Planning Application Ref: FG/169/20/T

Location: 41 Ferringham Lane, Ferring, BN12 5NB

Description of works: Reduction of branch to North face of ilex oak (T1) to 3m and raise crown to 4m above ground level. Removal of dead wood

SKETCH 1

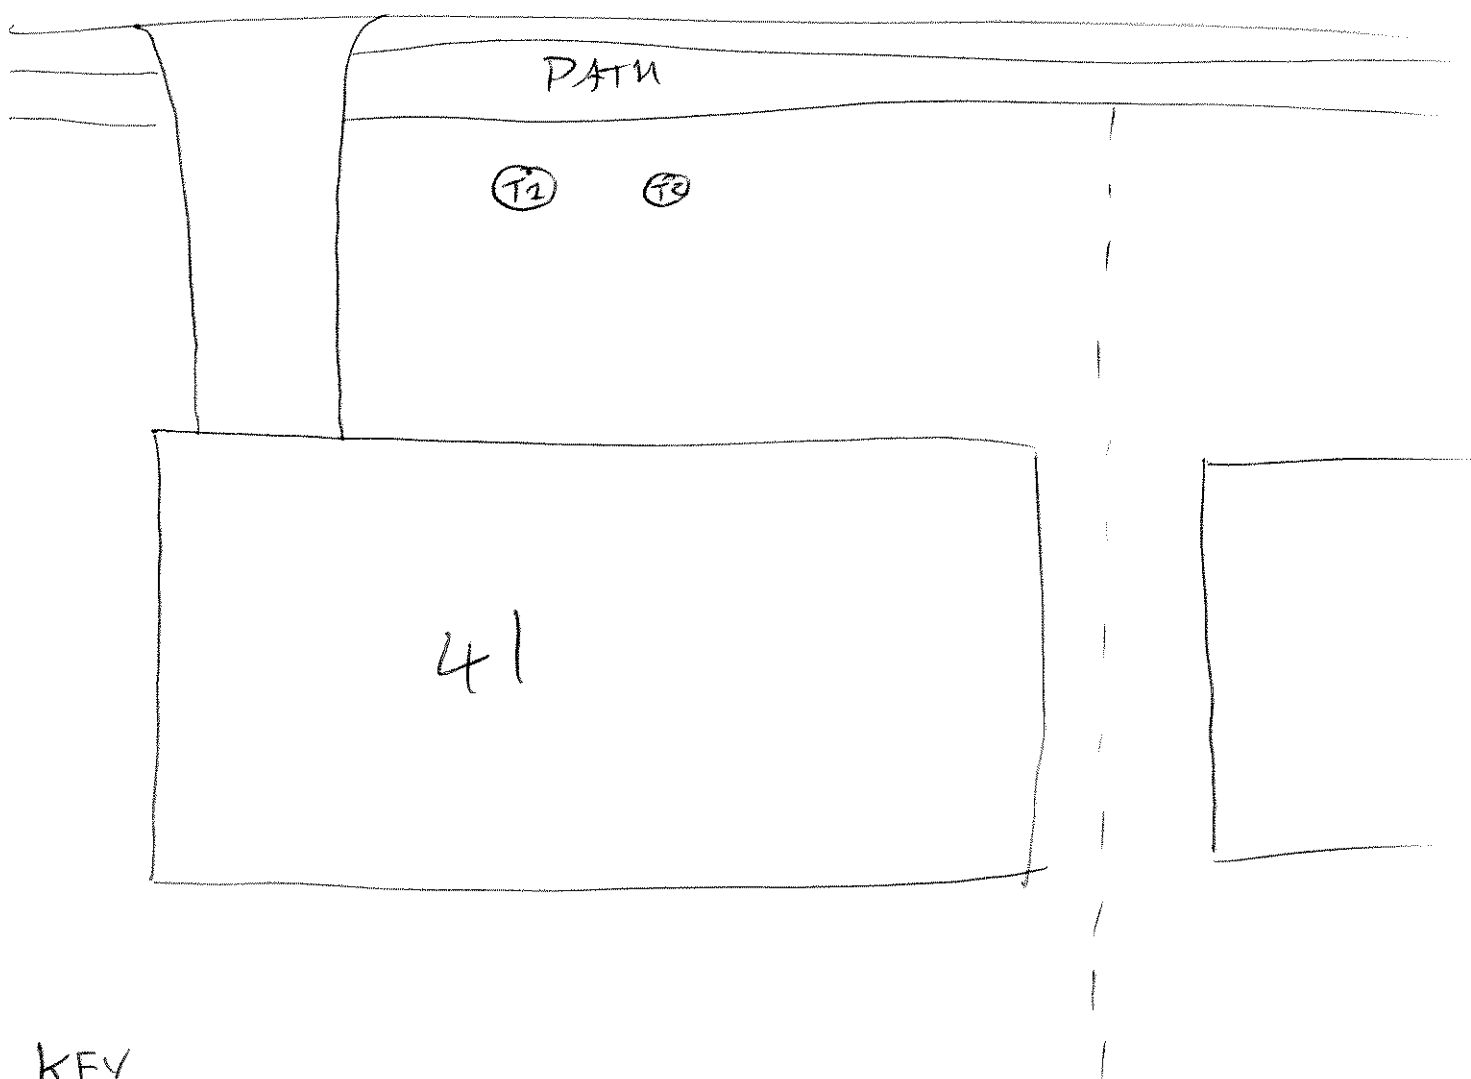
- Outwardly this tree appears to be in a fair physiological state with an attractive crown profile. It is prominent at the front of the property and so highly visible from numerous properties and to users of the highway.
- Lowest branches are approximately 3metres above ground, so the removal/reduction of small diameter low branches to achieve maximum 4metres clearance will have little visual impact on the tree. Reduction of a single branch from mid-height on the north aspect to minimum 3metres length will similarly have little impact if undertaken to a high standard. Both operations are within acceptable tolerances required by British Standard (BS3998:2010) Tree work – Recommendations.
- The removal of dead branches is an exception and does not require consent from the local planning authority.

- Although the work proposed has not been justified on arboricultural grounds, it will have only a slight and temporary visual impact with no harm occurring to the tree's ongoing health and vitality – if undertaken to a high standard.

- Part a) Where whole branches are to be removed and final cuts made close to the trunk or branch union they are to be made as shown in Figure 2 of BS3998:2010
- Part b) Where branches are to be shortened back the final cuts are to be made at the correct angle shown in BS3998:2010 and adjacent to a live bud or lateral.
